## MMC St. John Employee Garage - LIII Site Plan Conditions of Approval Submittal for Issuance of Building Permit

Hi Nell – I have reviewed information provided by the Applicant in conjunction with Site Plan Conditions for Parking Garage Circulation and Provision of a Construction Management Plan for off-site roadway construction. My comments are noted below.

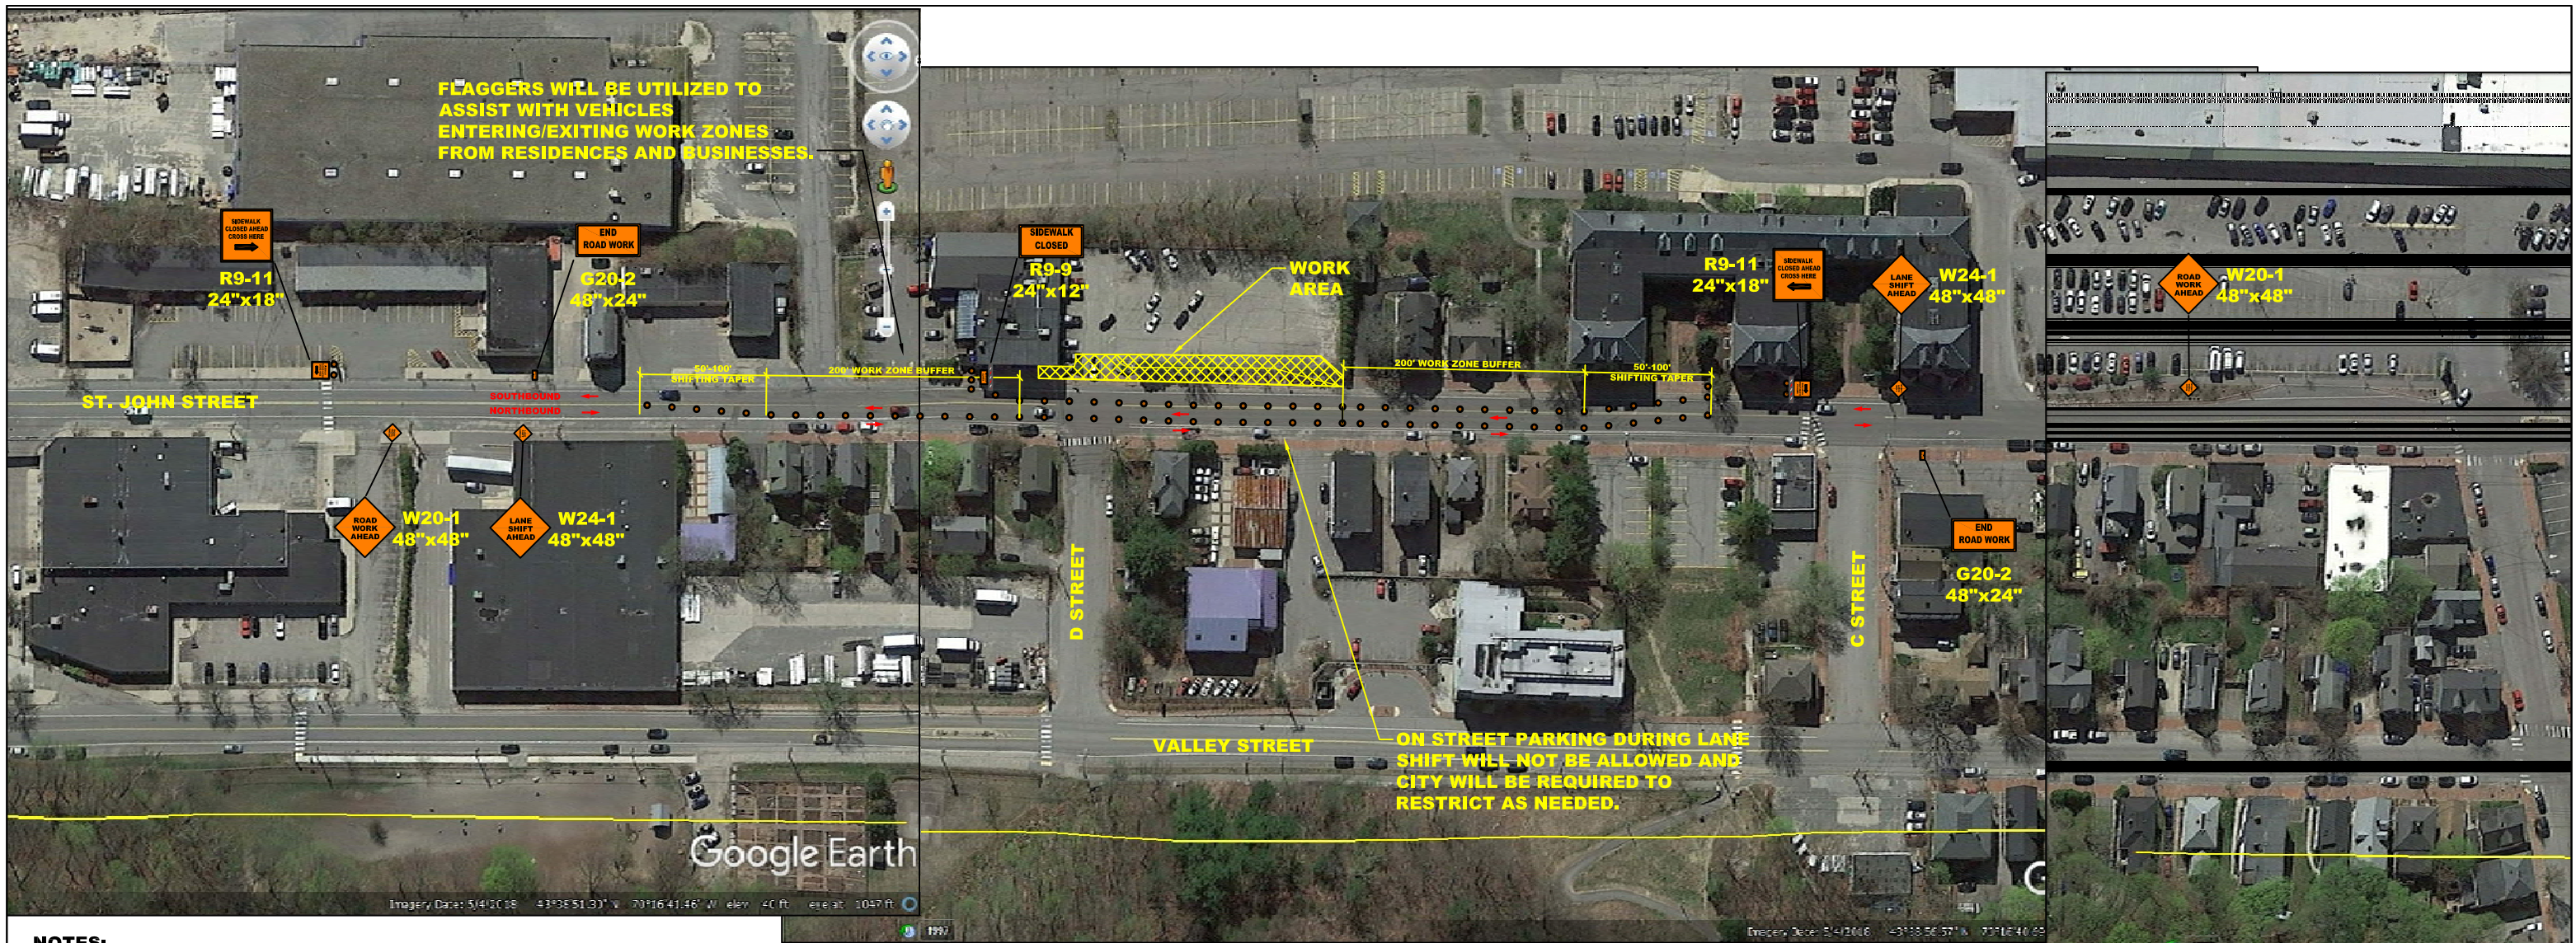
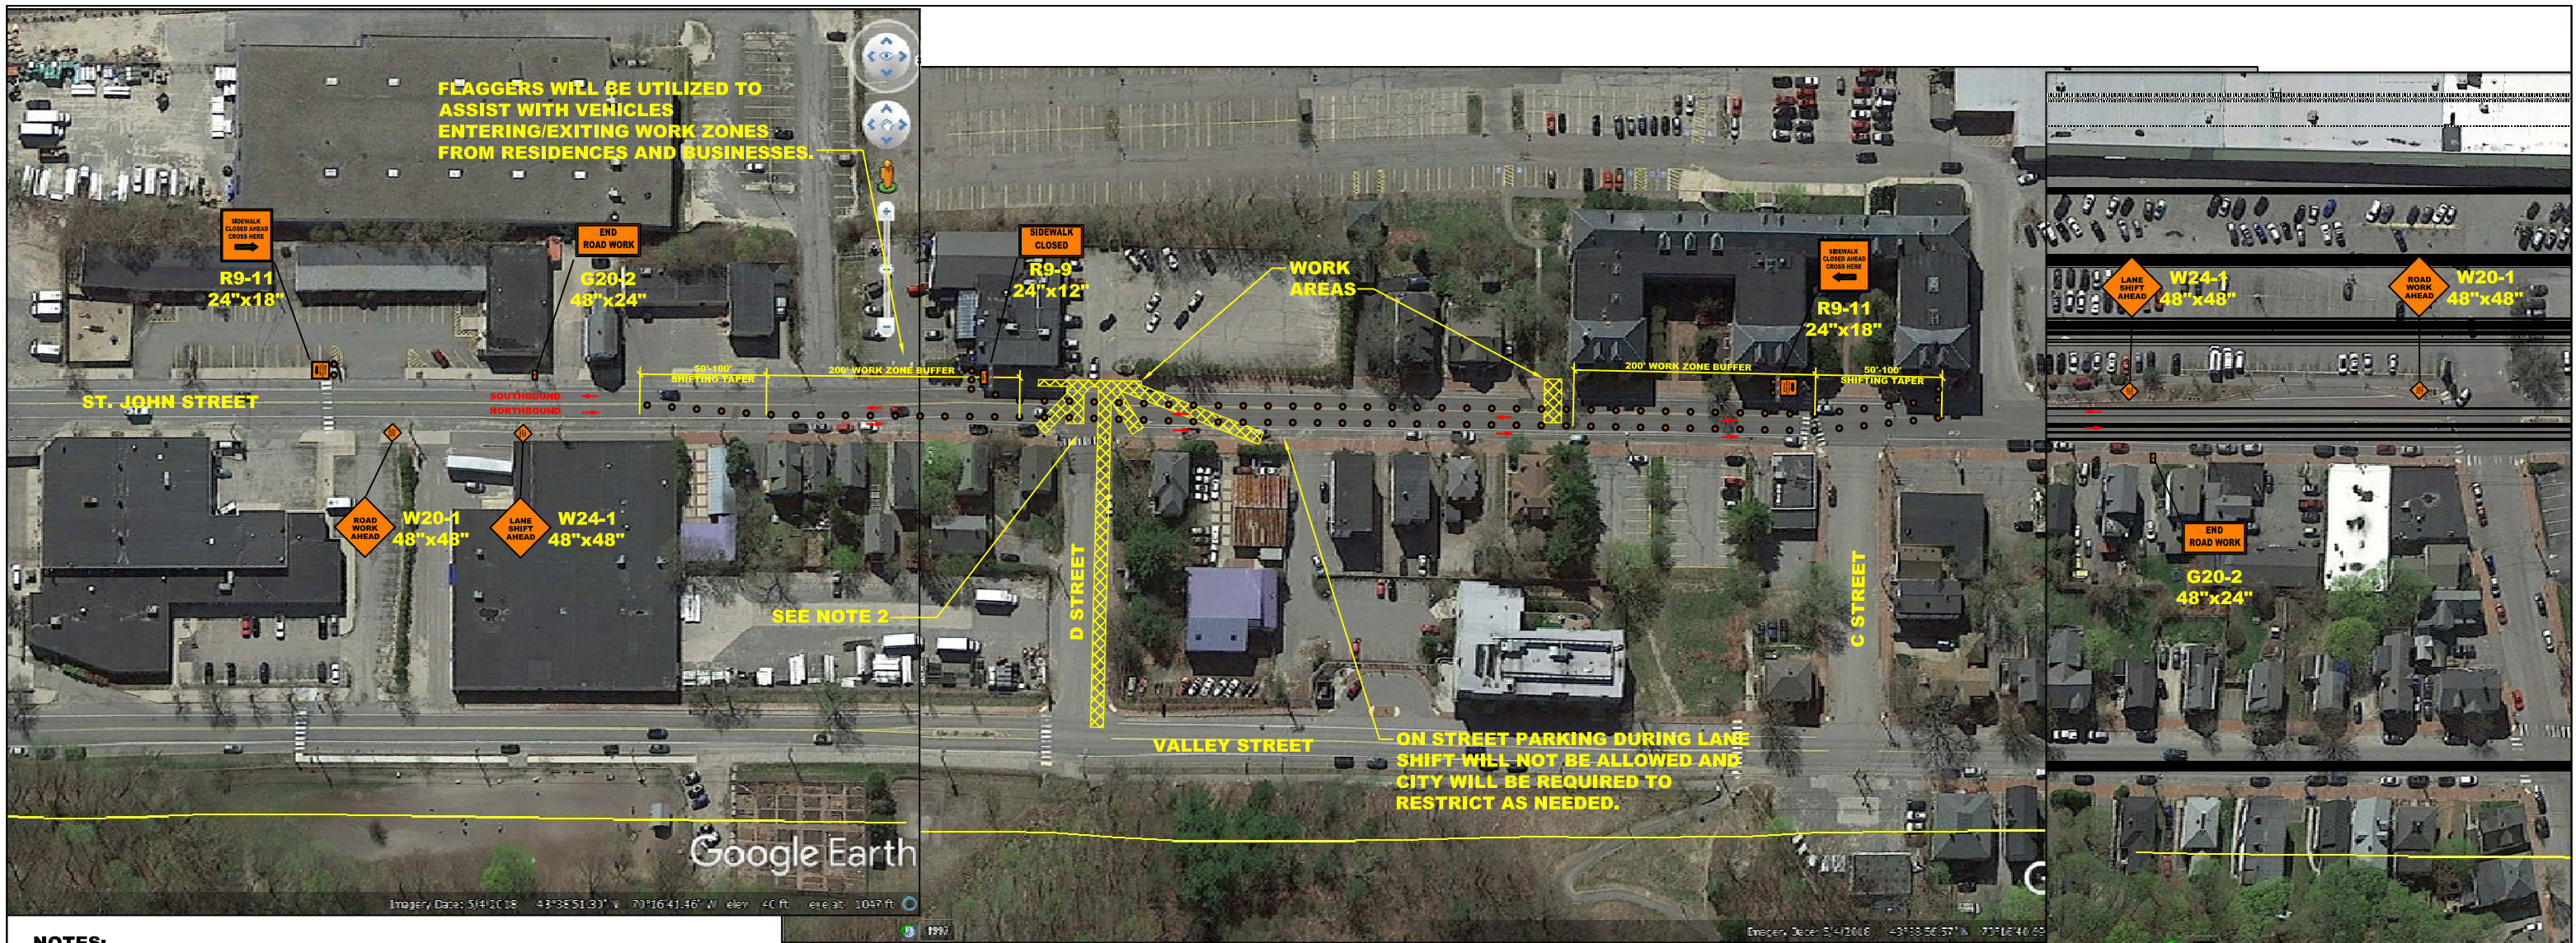
- I have reviewed the September 24, 2018 Memorandum prepared by VHB and their conclusion (*We believe that the current design and access/circulation configuration, coupled with key technology provisions, will support efficient entering and exiting maneuvers by MMC staff and will not impede traffic operations along St John Street*) seems reasonable and accordingly this condition has been met.
- The Applicant provided very general information as it relates to St. John Street, D Street, and Valley Street construction management plan details. I would suggest that greater detail be provided prior to the issuance of a City Street Opening Permit.
